Town of Addison
Summary of Engineering Revision Comments

Development: Galaxy FBO

Town Project #:19-09D

SHEET NUMBER
C17.02

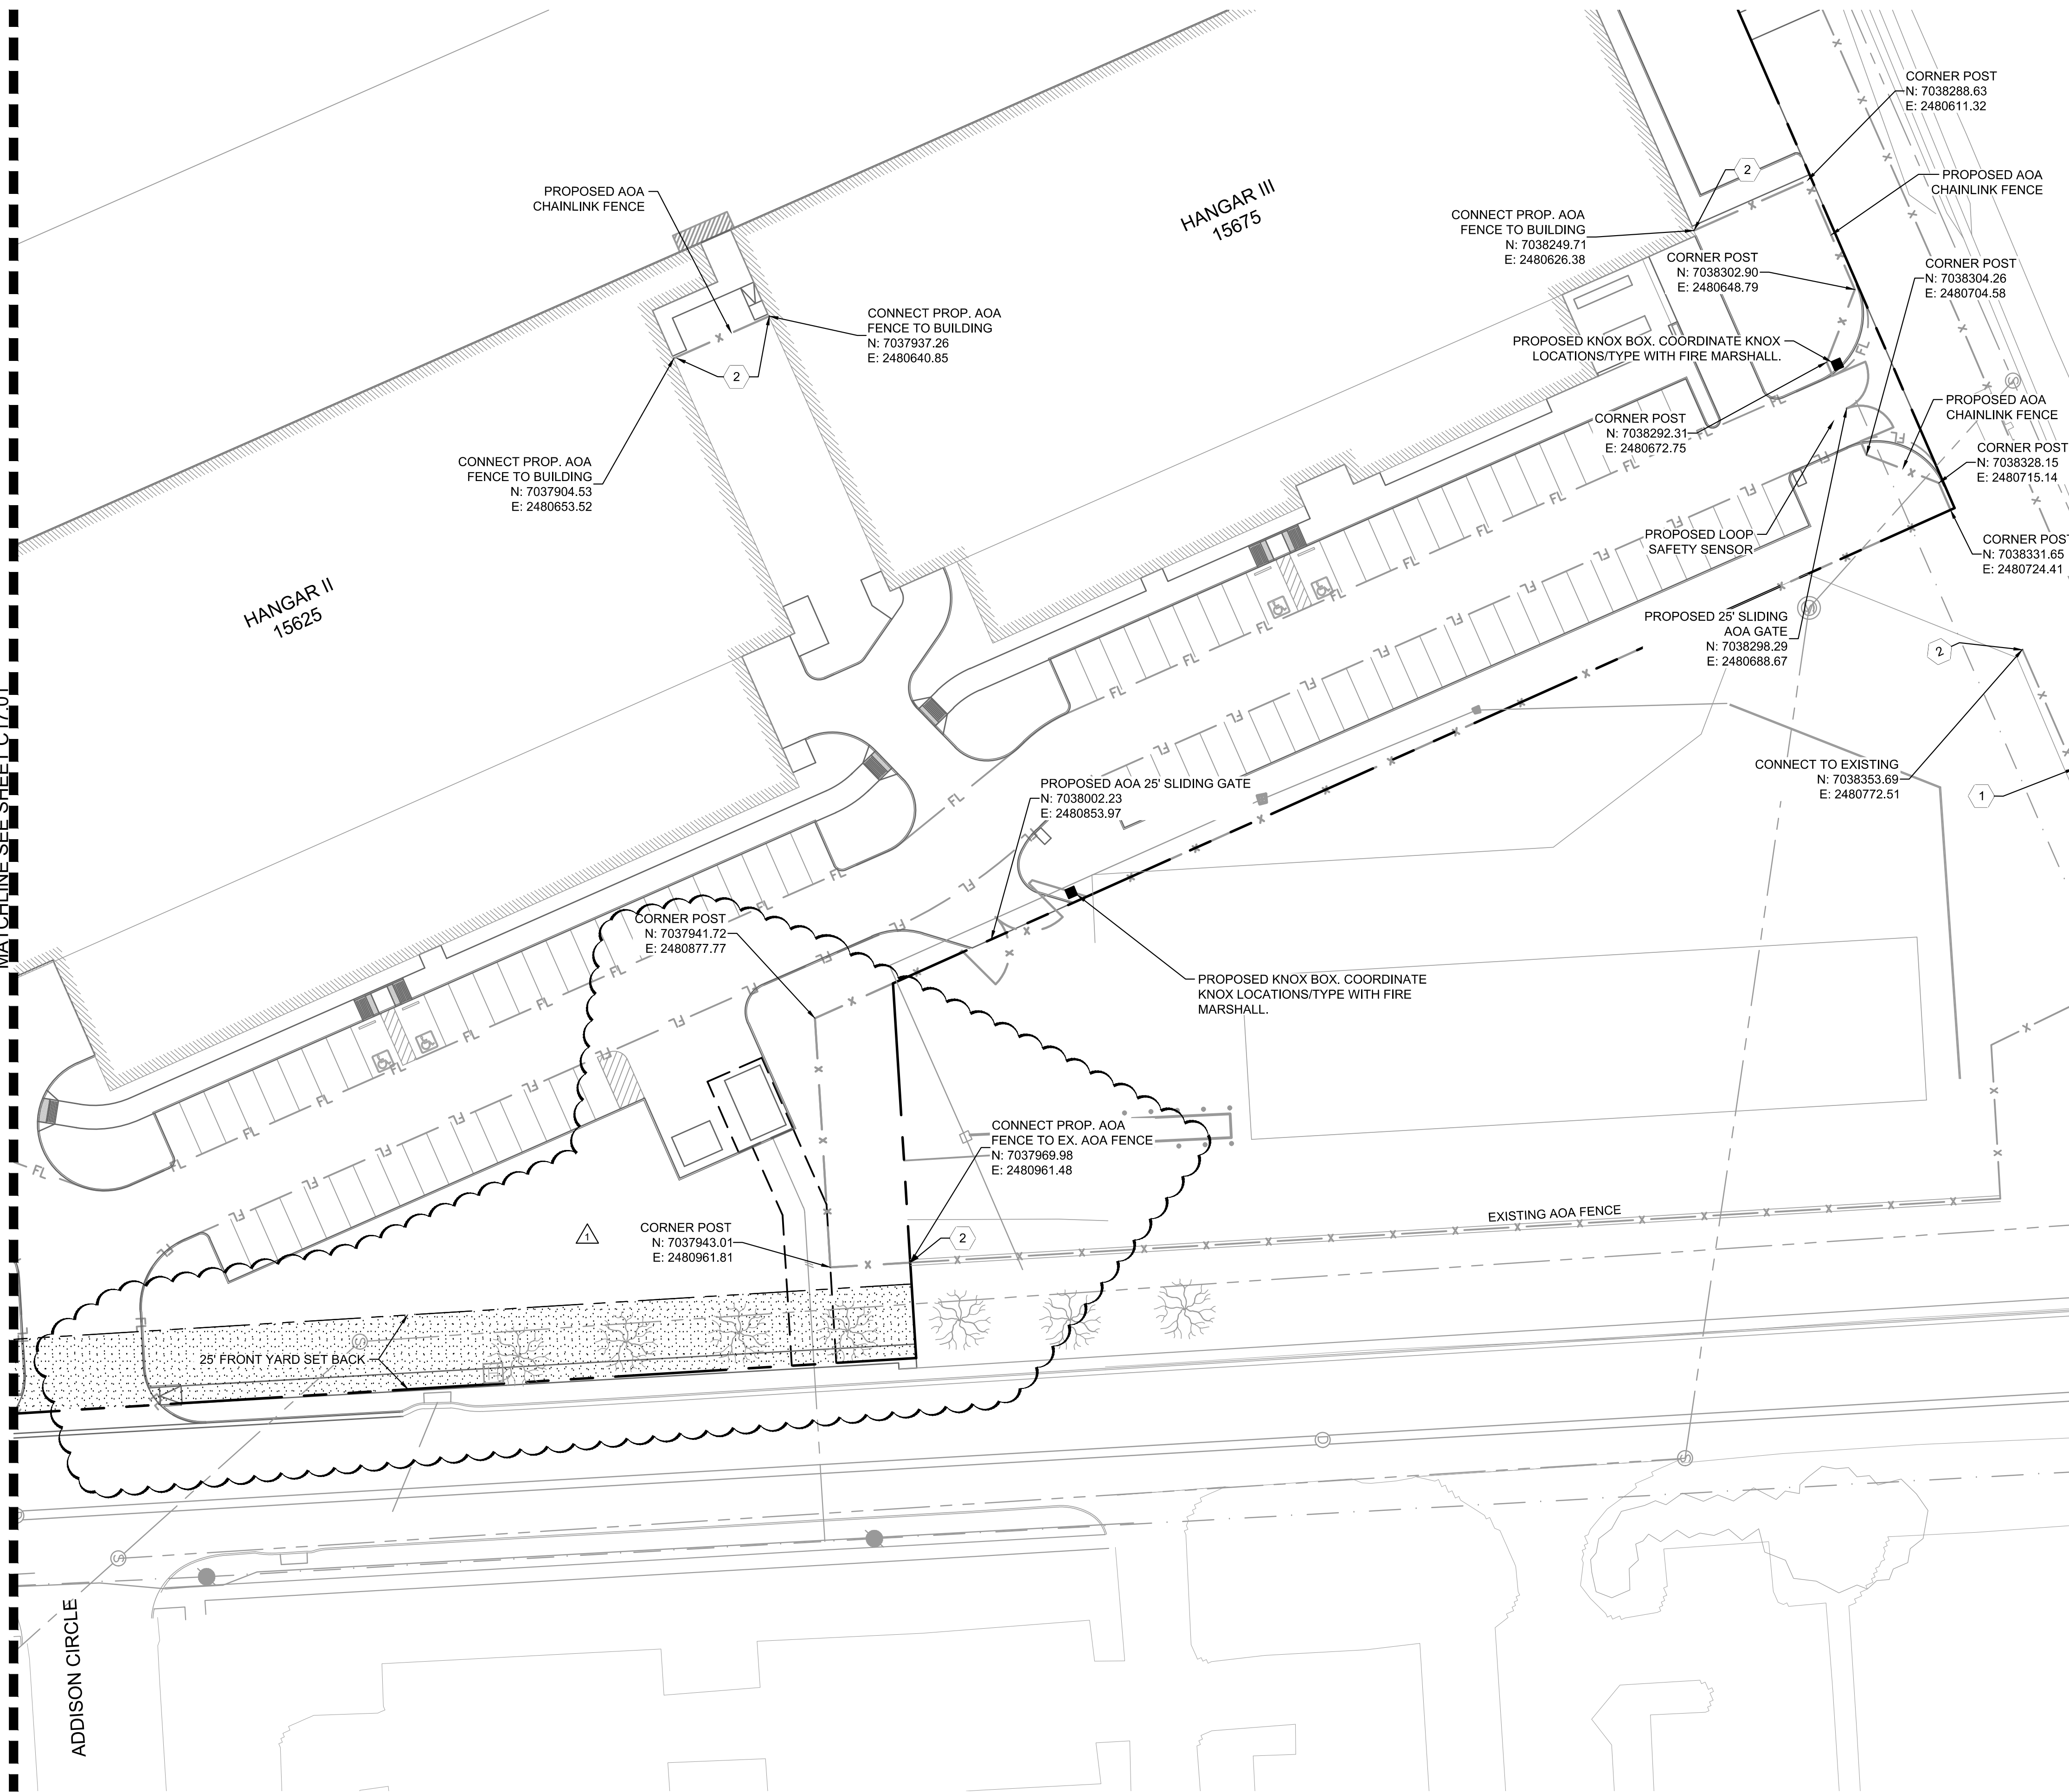
ASI-C005	8/7/2020	C17.01	Moved the chain link fence on the east side of the parking area on the south end of the site so it is outside the 25-foot front yard setback, and removed the ornamental fence and gate previously proposed along Addison Road.	
ASI-C005	8/7/2020	C17.02	Removed the ornamental fence previously proposed along Addison Road.
